Local Policing Supporting Team

Your Ref: BE/135/18/PL

Date: 22nd January 2019

RE Saltbox Field , land off Rowan Way, Bognor Regis PO22 9NW

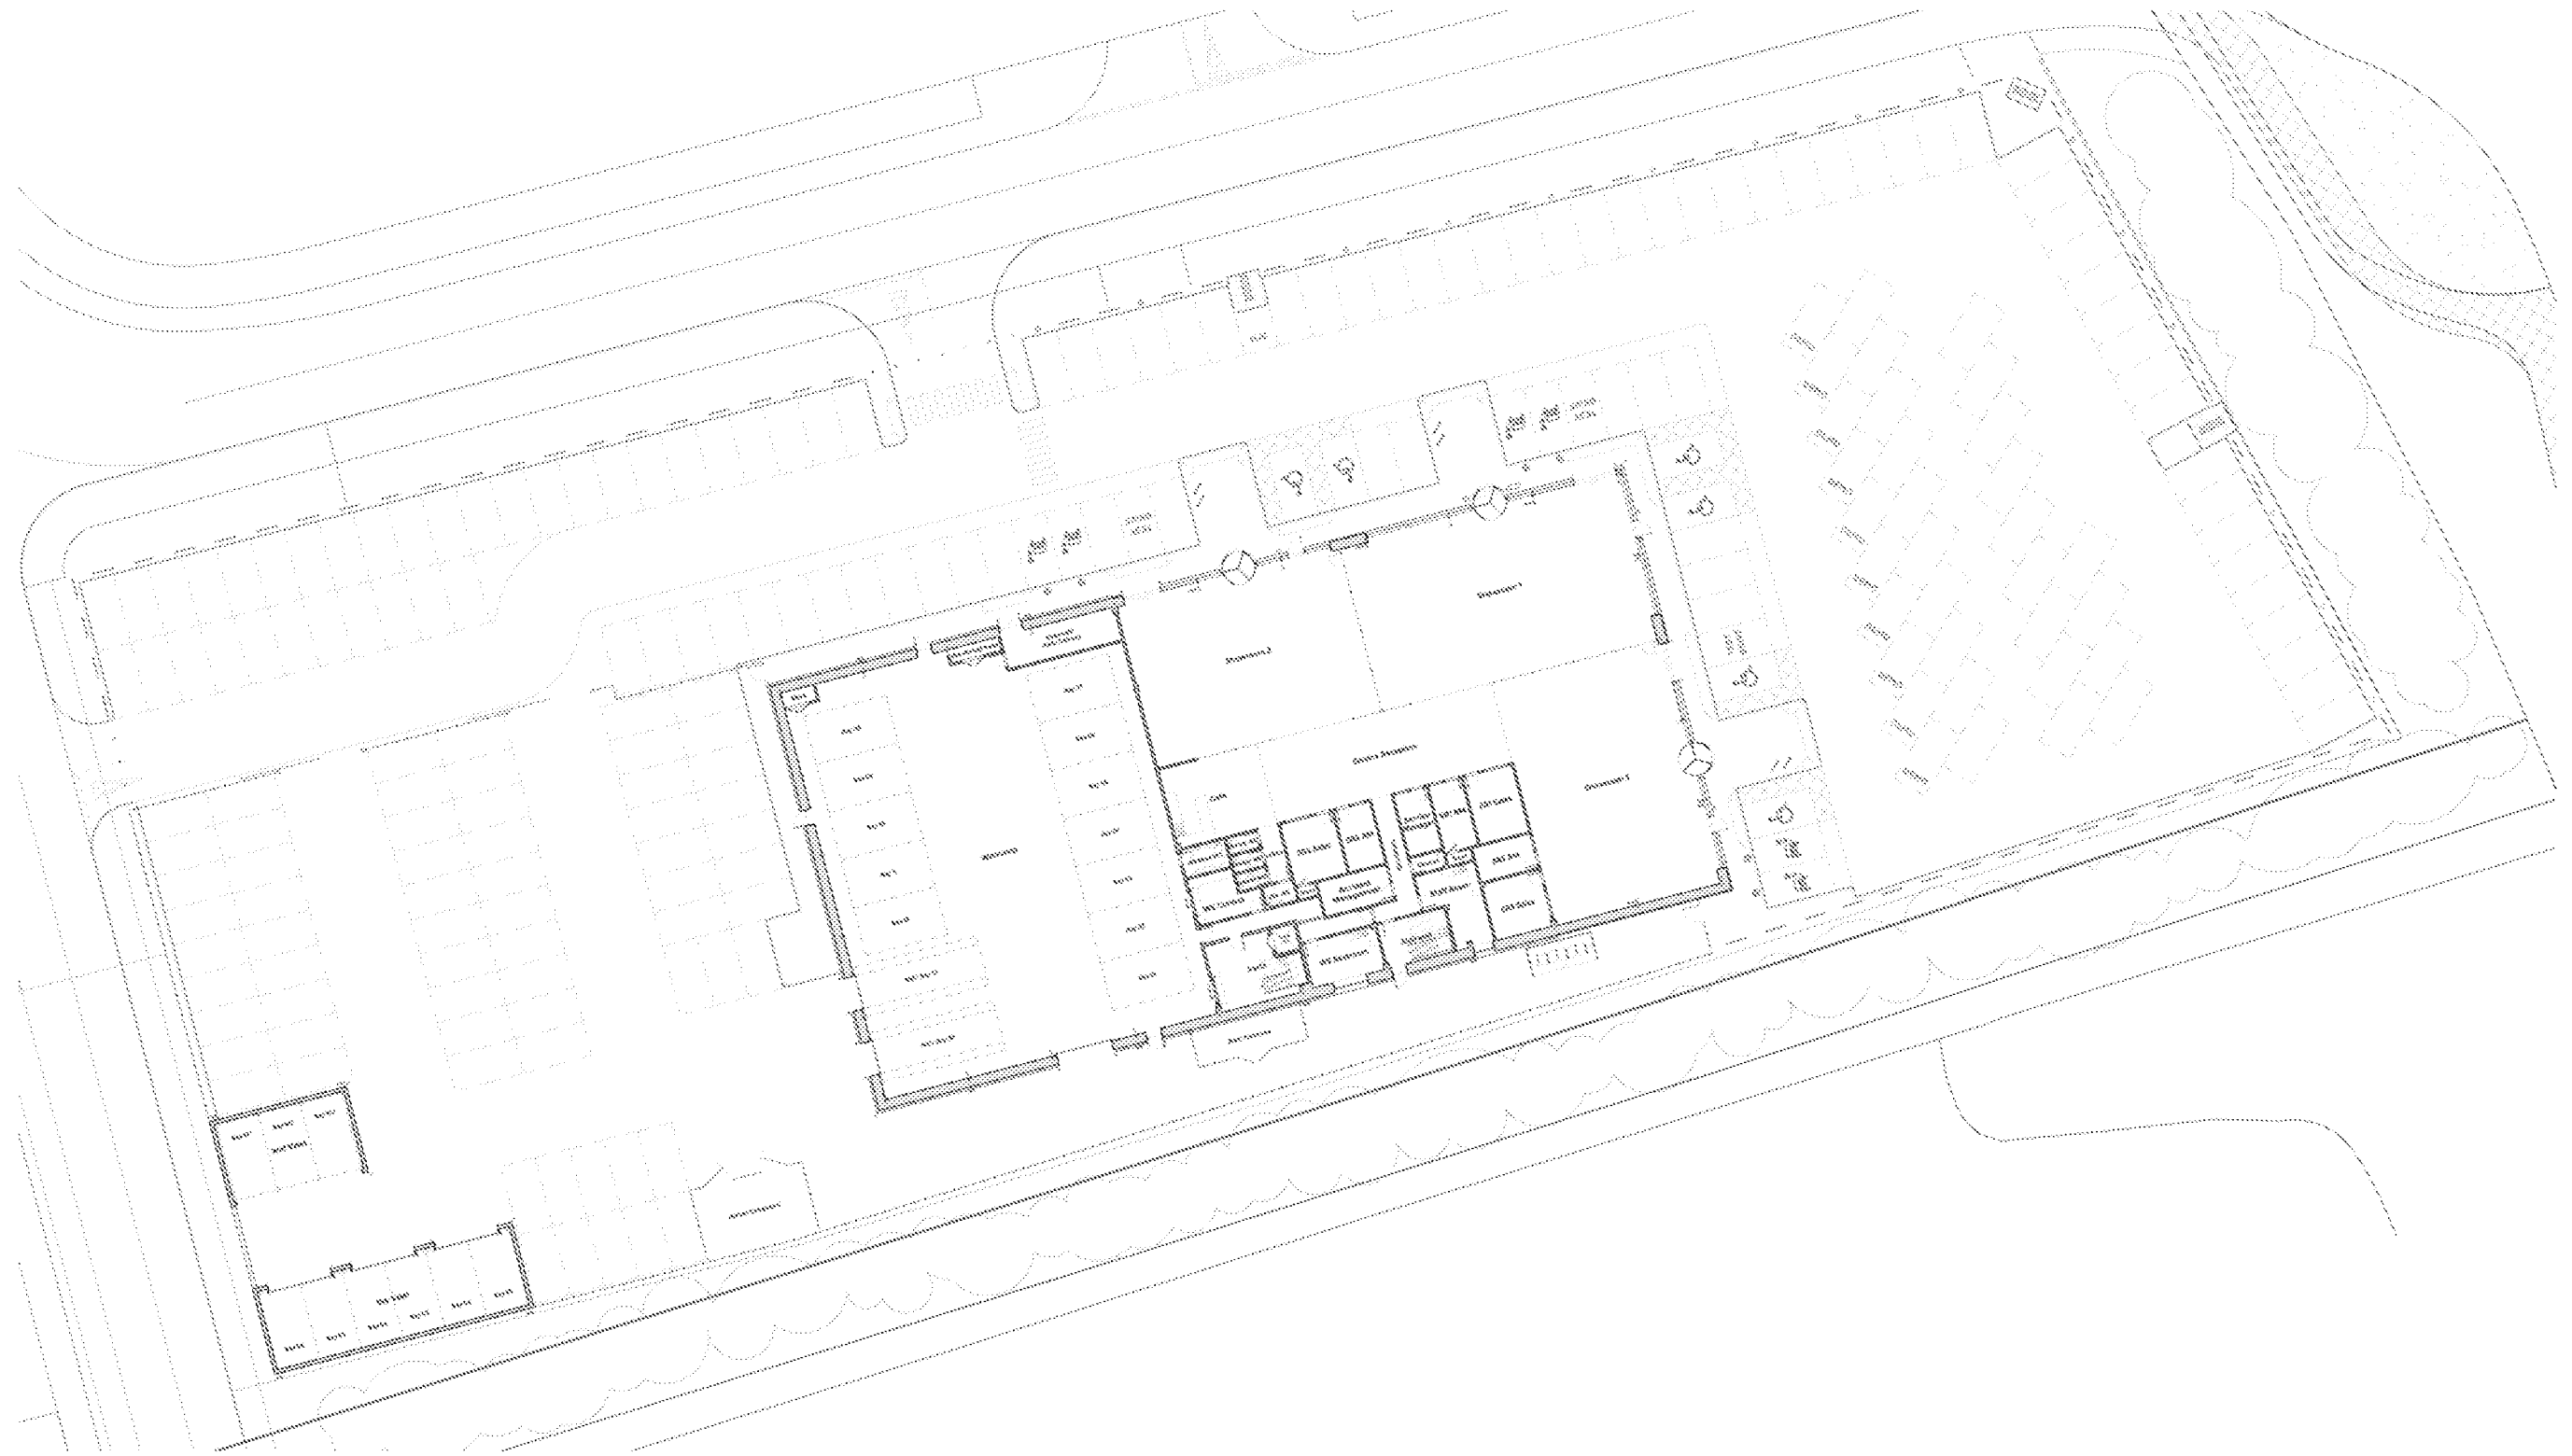
Immediately to the south of the rear of unit 9 is a public right of way which could provide an easy route , isolated from view, to use to attempt access to the rear of the car show room or storage area without being detected, and so security fencing is also required along length of the premises. I note that 2.4 metre high security fencing is to be installed. There must be no external features that would allow climbing over or access underneath it.

I note the car show room has steel hoop barriers to prevent the theft of the vehicles on show in the open forecourt , but as they are still vulnerable to unauthorised access and criminal damage, additional CCTV and lighting would be an added deterrent (CCTV alone may not prevent crime occurring). Any CCTV considered should be commensurate with lighting systems.

SITE MASTERPLAN
PHASING PLAN
1744-P02-A

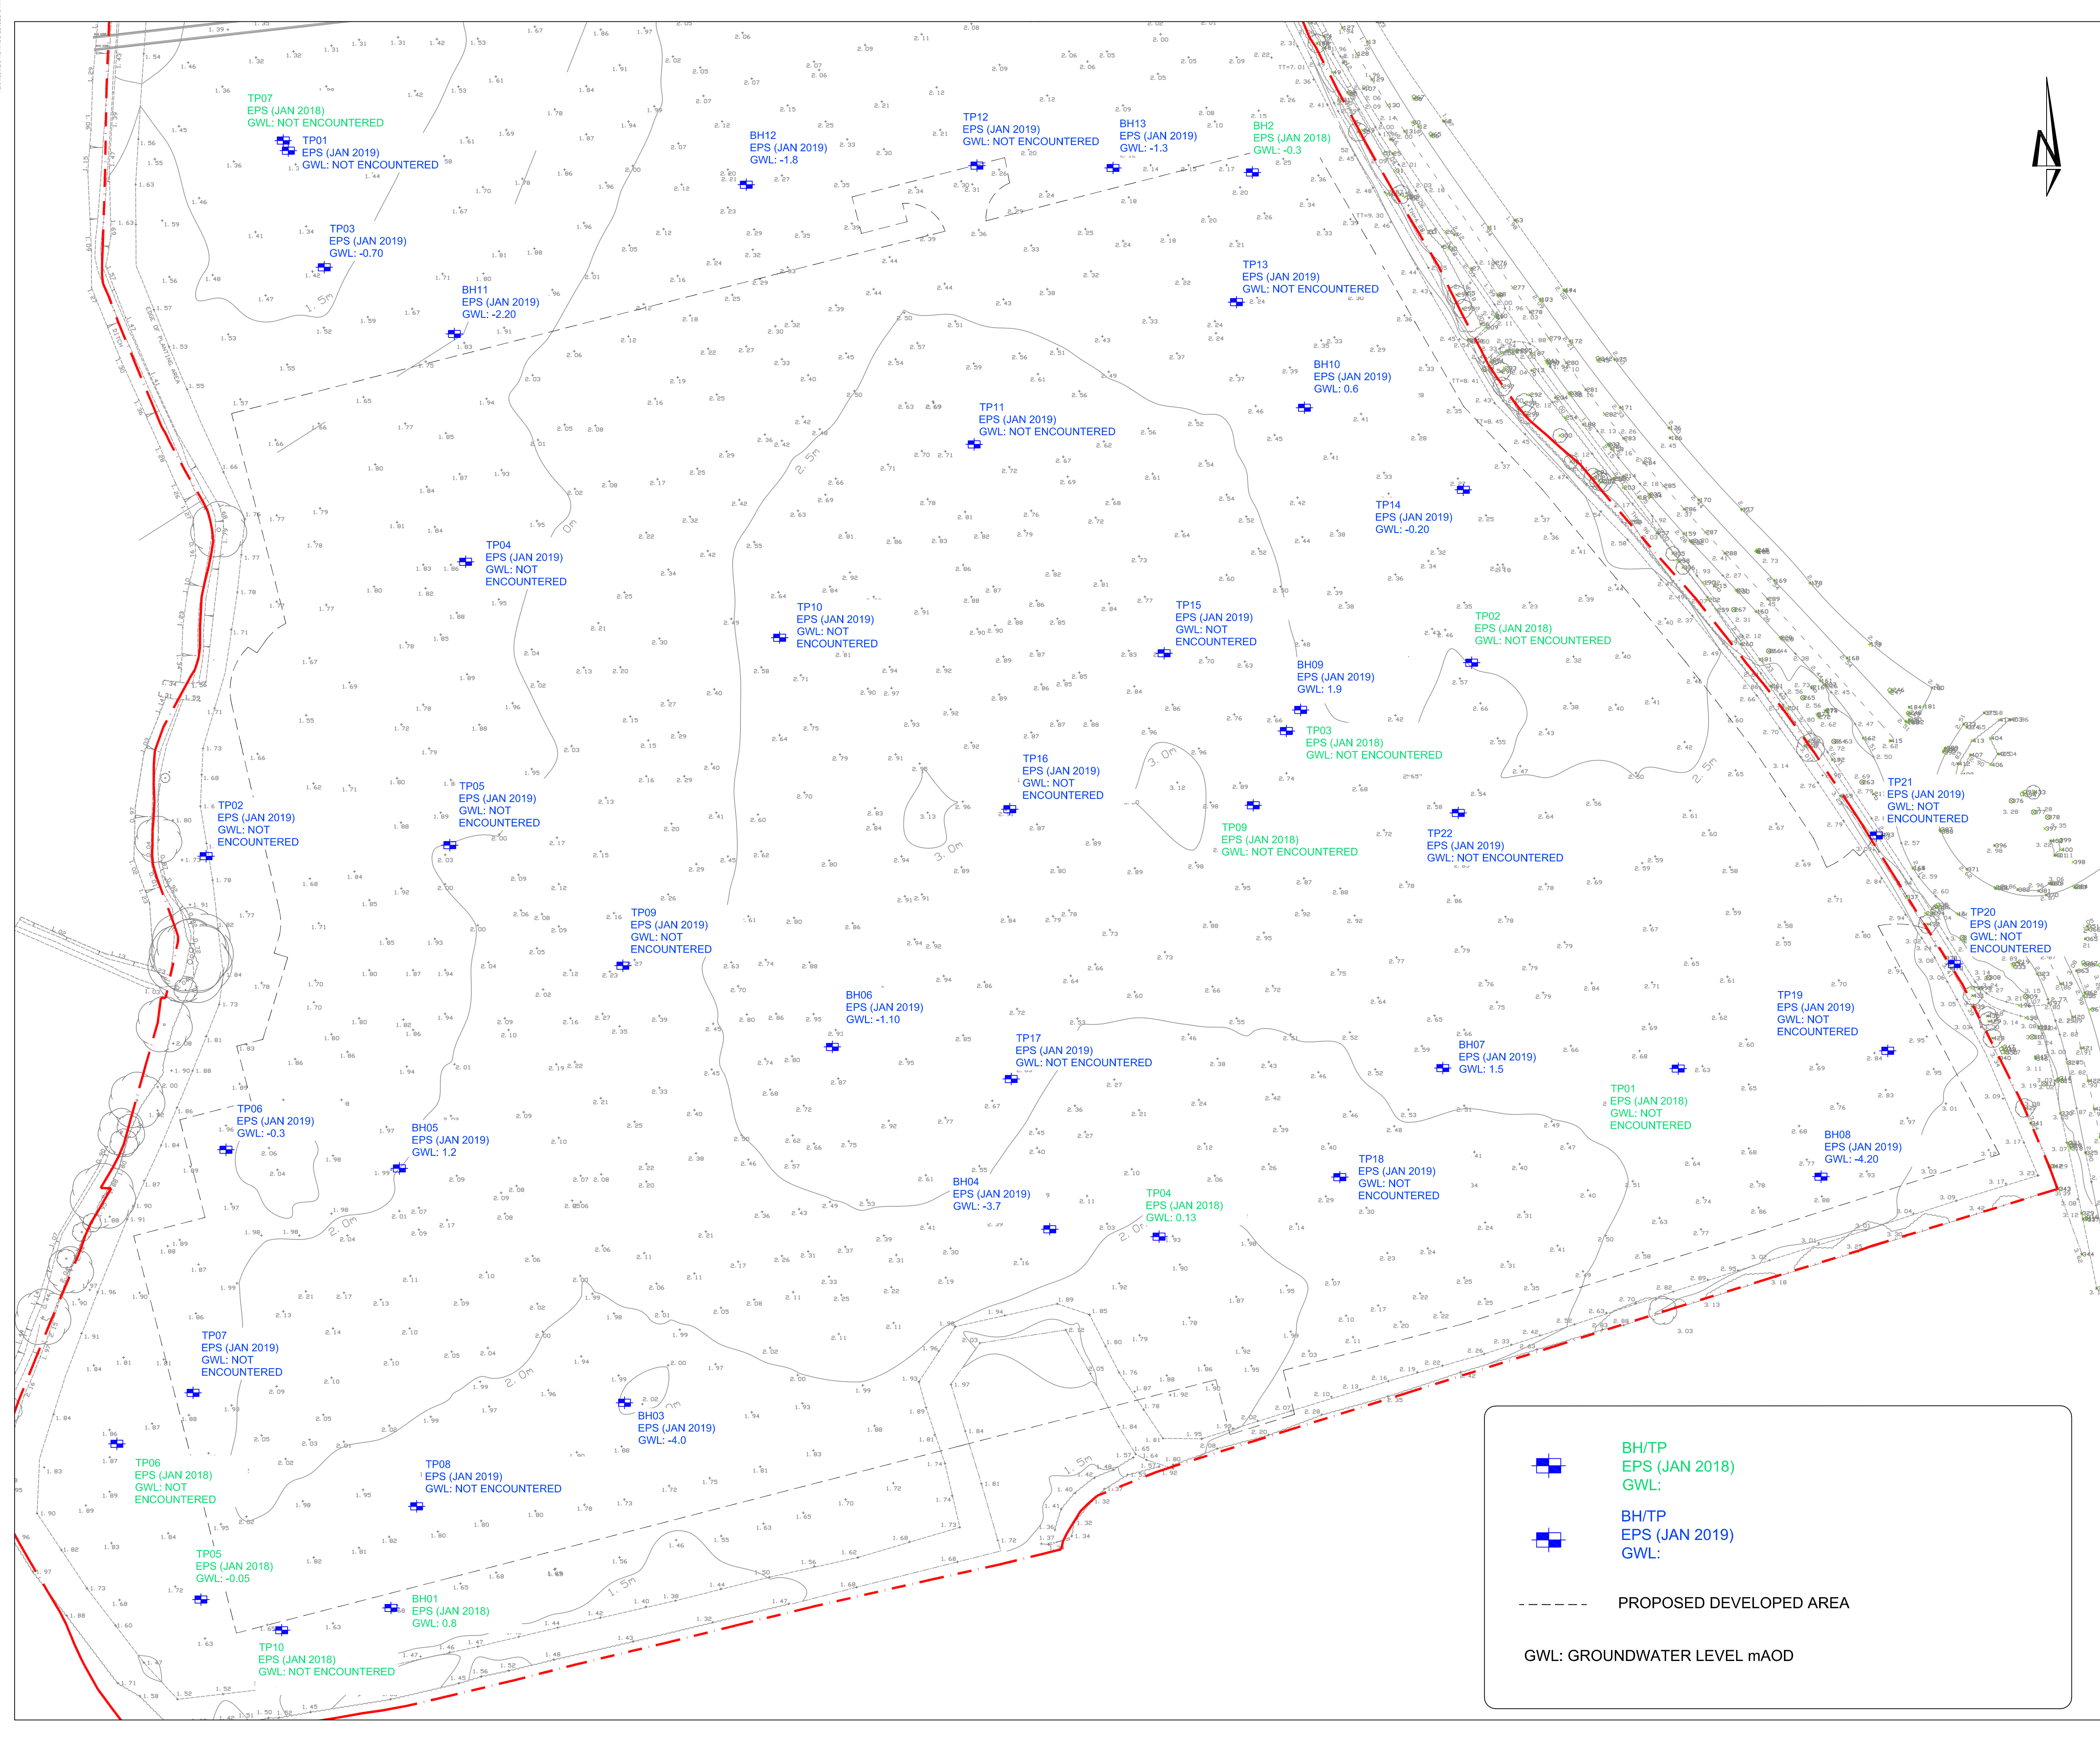
This application has a single uncontrolled road access / egress from the roundabout on the A259 Shripney Road and so access can be gained 24 hours a day by anyone in a vehicle or on foot for legitimate access or unauthorised access. This multi-use entrance would be very difficult and impracticable to provide security for the whole application which is very permeable, and so each unit must ensure it provides its own security measures.

I recommend that all warehouse units have secure perimeter fencing with gated entrances and controlled access.

I reiterate comments from my previous letter that Unit 1 has a perimeter fence with a gated entrance at its western end. I would recommend that its northern entrance also has controlled gated access to deter unauthorised persons and vehicles entering the loading / manoeuvring areas.

Between Industrial Units 6 & 7 I would recommend there is a substantial fence or dense planting and security gate with access control to ensure there is no access from public areas.

Similarly, the rear of units 2 and 3 are out of view and possibly accessible from the 'village buffer' and should also install similar height security fencing.

Consideration should be given to a controlled pedestrian access from Shipney Road and also to the car park entrance into Warehouse Unit 3 to prevent unauthorised persons or vehicles entering the industrial units. This will also benefit security for the cycle racks near the Shipney Road access.
